**Town & Country Planning (Control of Advertisement) (England) Regulations 2007 (as amended)**

**Application for Consent to Display an Advertisement(s)**

**Development:** Installation of 1 No. externally illuminated fascia sign.  
**Location:** 26 Felpham Road Felpham PO22 7AZ

ADVERTISMENT SIGNAGE - FRONT FACADE LETTERING

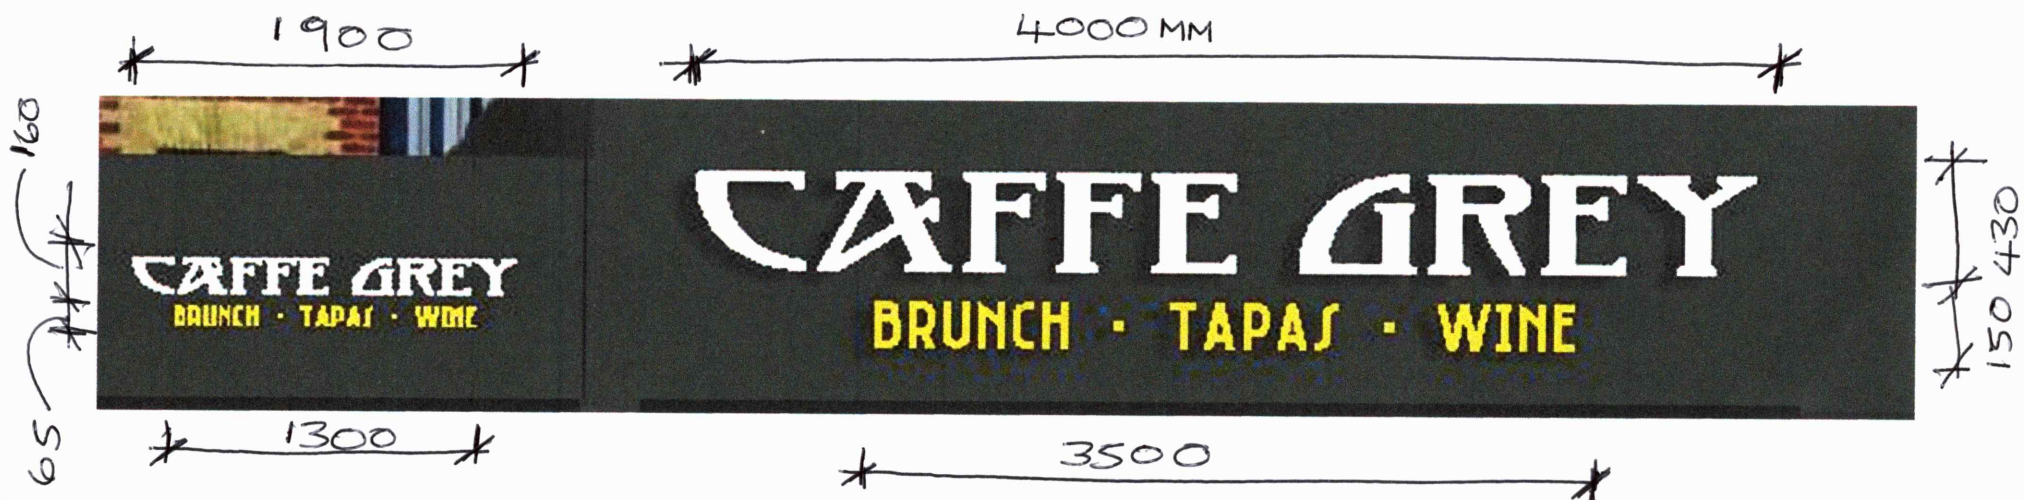
The dimensions of the proposed sign should be clearly annotated on the proposed photograph. Please amend accordingly and re submit.
